From: Nicola Spencer
Sent: 20 June 2017 12:54
To: Karen Parsons
Subject: FW: Fitzalan Link - LU.234.16.RES

As set out in Tim's email, there are three points that need to be addressed, the rest of the issues are detailed design issues. Please could you let me know what your response to the issues is so we can progress the application. If a different surface is being proposed to the one that was modelled then the modelling will need to be revised. Please could you also agree an extension in time until the 31st July in order to allow sufficient time for revised plans to be submitted and considered and the updated Safety Audit to be submitted and reviewed by WSCC.

Following review of the submission, WSCC comments as follows:

In summary, there appear to be just three outstanding points now – the choice of road surface, the requirement for a new or supplementary Stage 1 Road Safety Audit and the design of the shared footpath-cycleway connection to Highdown Drive close to the new Toucan crossing now proposed. The other points can be tied-into the detailed S38/S278 submission.

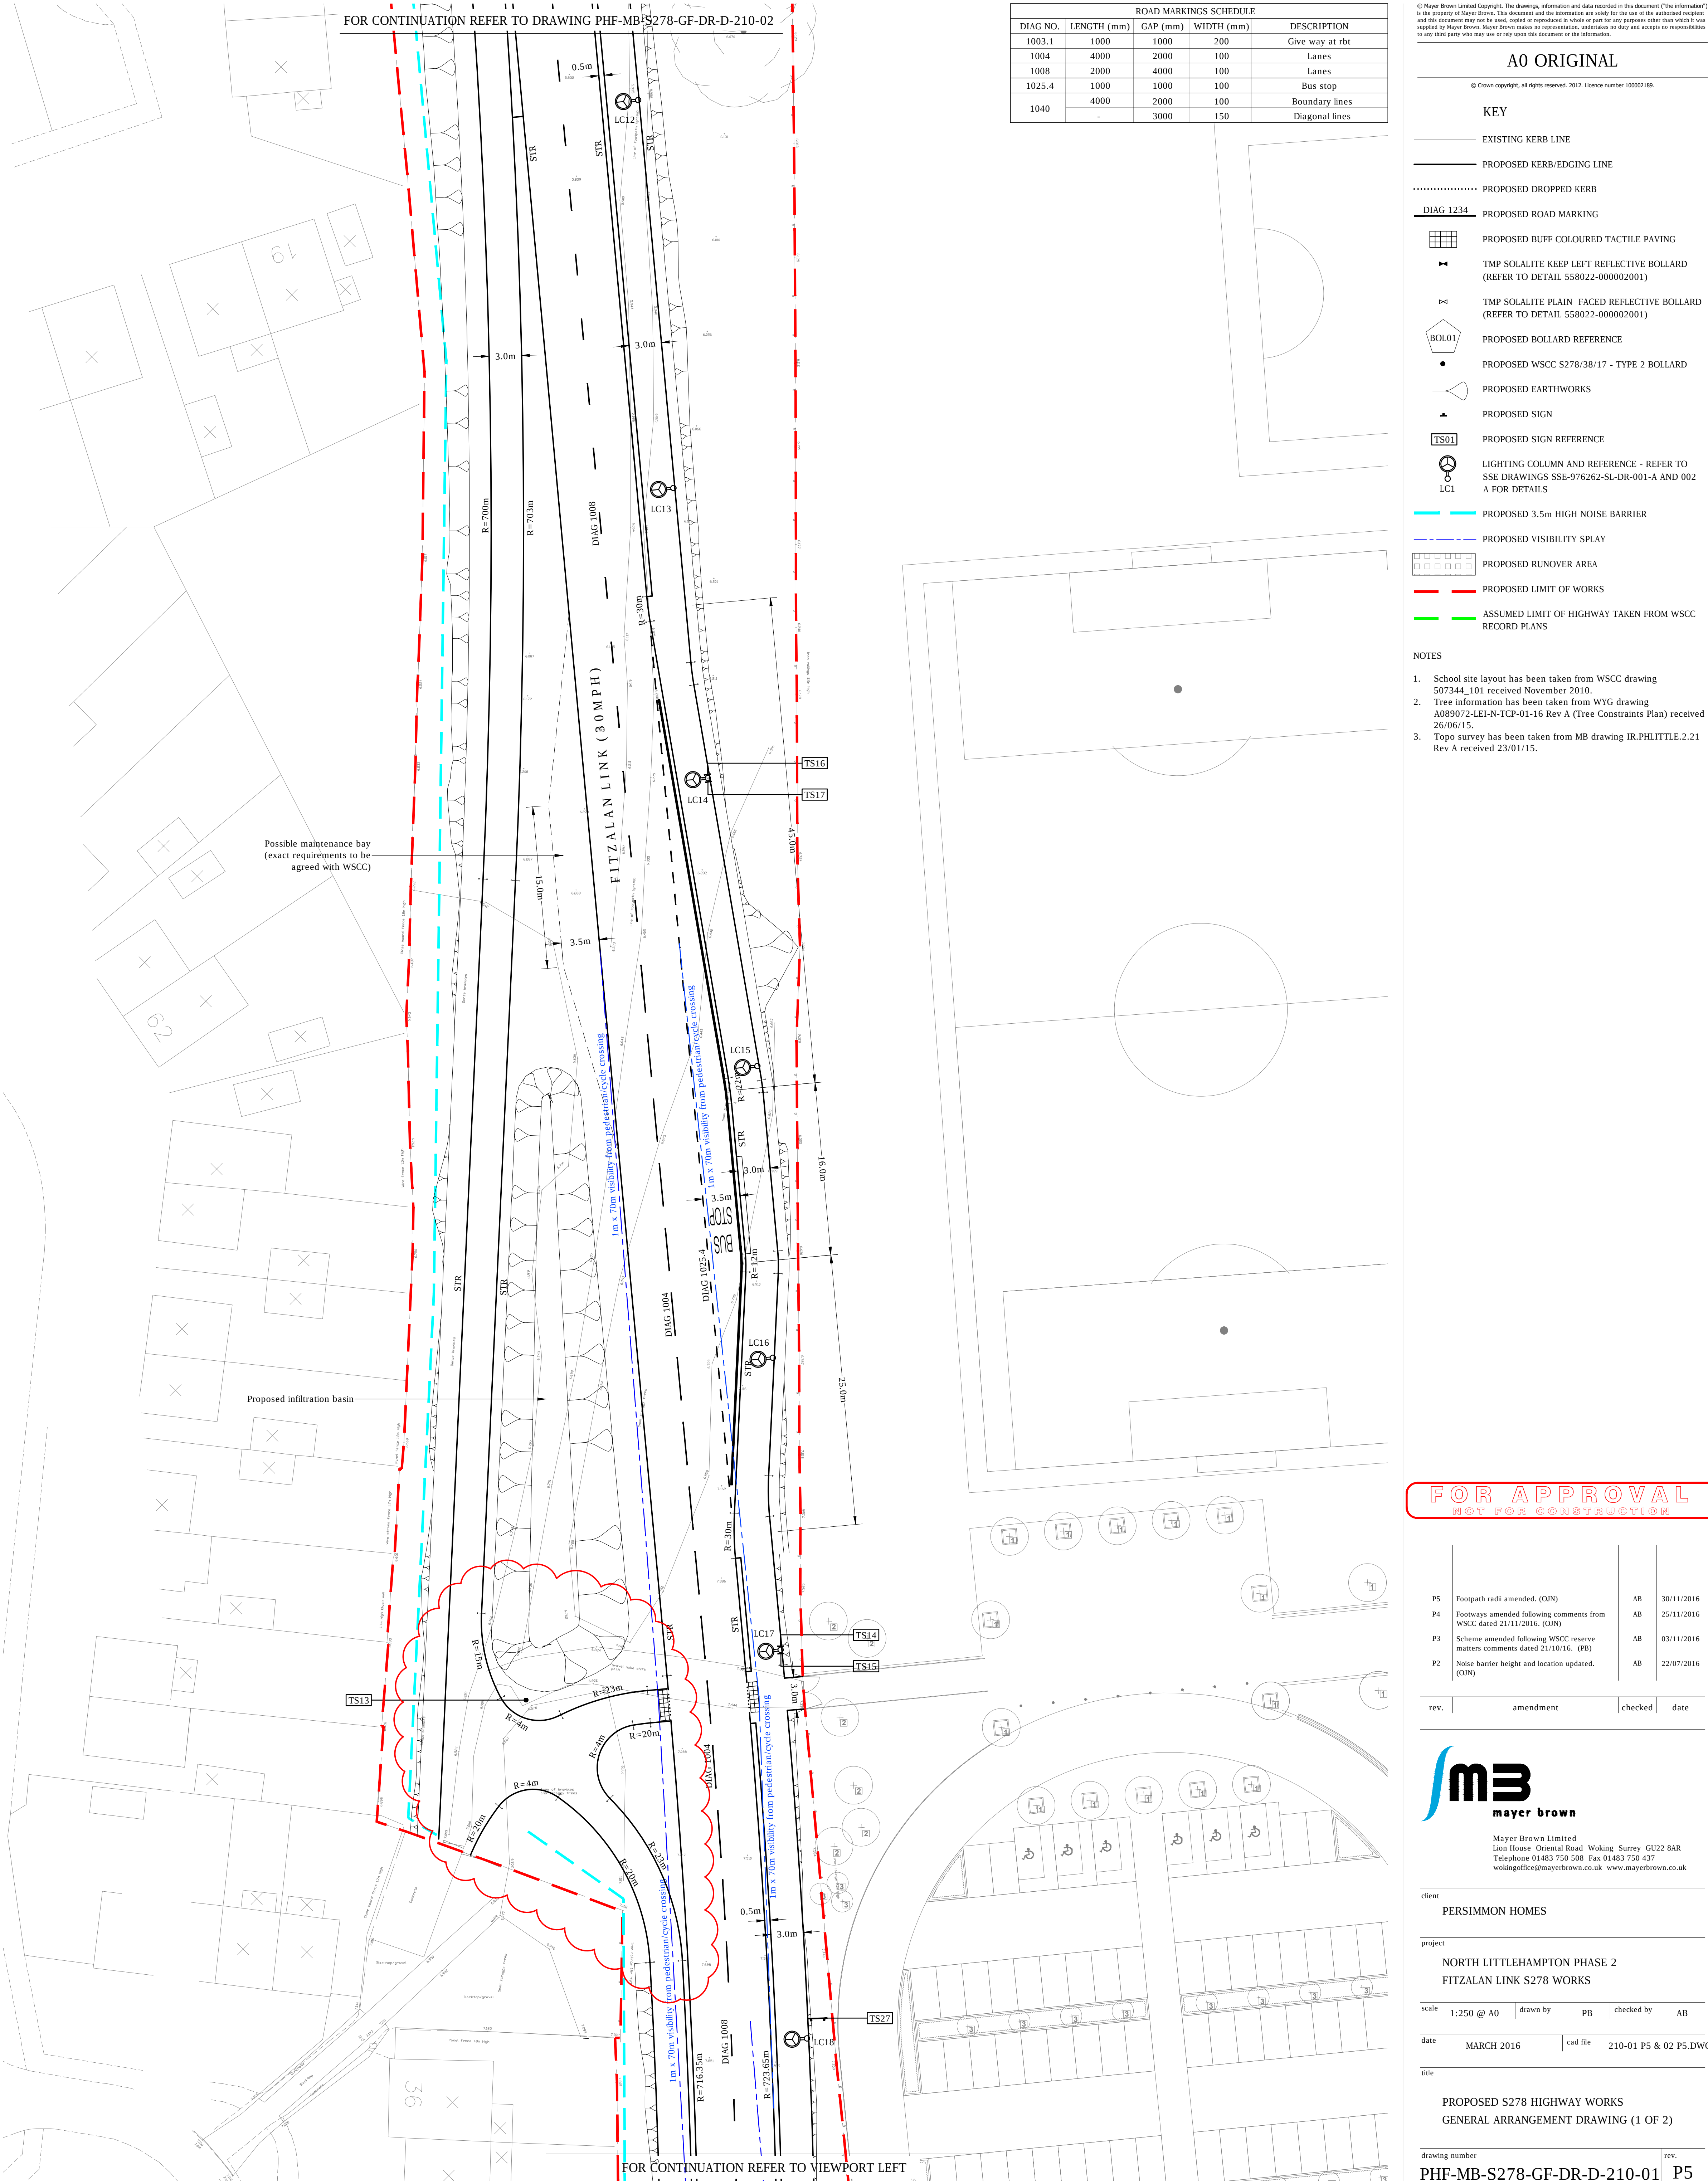
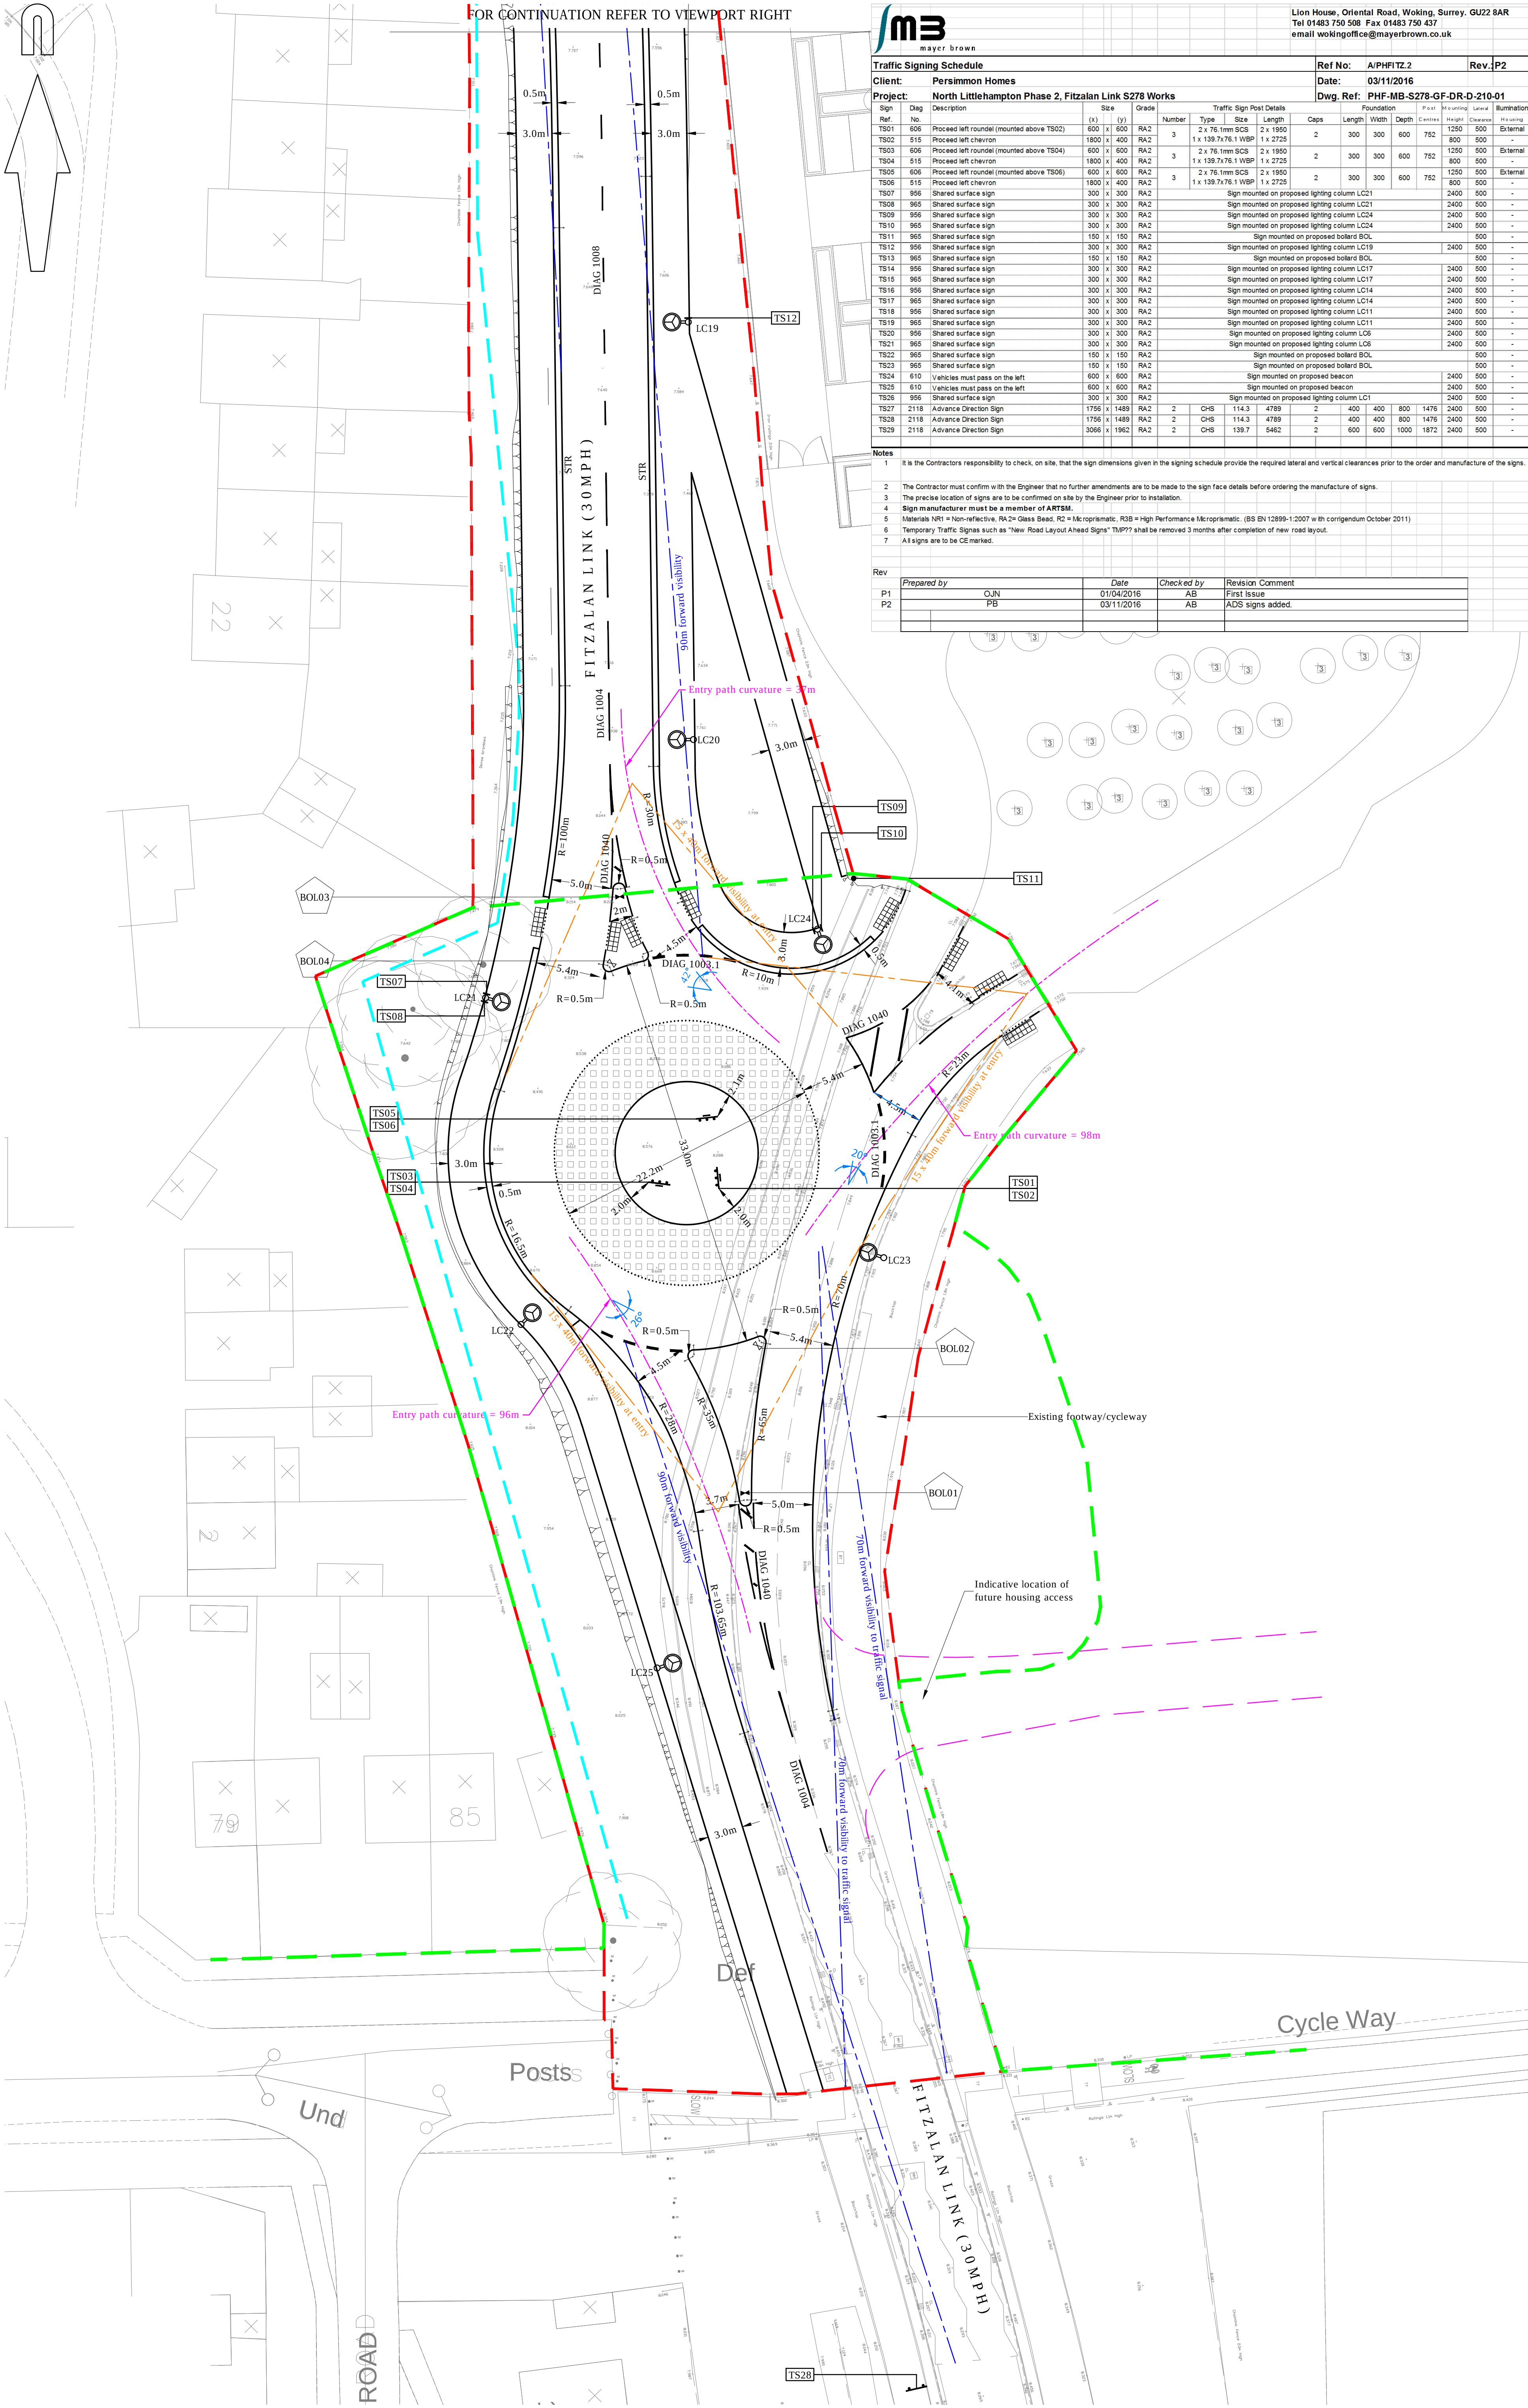
The drawings show a pervious road surface. This will not be long lasting enough. The best WSCC can consider is a negative textured road surface. However, this will not absorb as much noise. Your designer will need to look into "German SMA" which is an SMA with a high binder content and use an appropriate noise reduction factor.

Academy roundabout northern traffic island has a tactile paved crossing point. Given that it is narrow (the tactile paving on the drawing appears to 'meet'), consideration should be given at the S38/S278 stage to widening it or adjusting the position of the tactile paving (if possible) to improve width for pedestrians. However, in doing this you should also ensure that the swept-path of vehicles can still adequately negotiate the roundabout without compromising safety for pedestrians on the island.

Recommend that at the detailed design stage, the cycleway on the east side be locally flared at the controlled crossing to provide additional width for waiting pedestrians and cyclists. Also, that LC 17 be moved to the very back of the space available, away from the area of conflict where there would be interaction between pedestrians and cyclists. WSCC recommended to increase the crossing width beyond the minimum so as to provide more space for waiting pedestrians in order to help keep the cycle route clear. The location of the control box must be carefully considered to avoid obstruction for users and visibility. Finally, it is recommended that corner radii be applied between the cycle paths at the school exit next to the crossing and that pedestrian and cycle intervisibility is provided at this location.

Thank you for showing a northbound bus stop and layby. Where possible (and again at the detailed design S38/S278 stage), additional path width should be provided at *both* bus stops to allow passengers to wait clear of the cycle path. Also, please consider where bus shelters might be placed, and what form these would take given the space available.
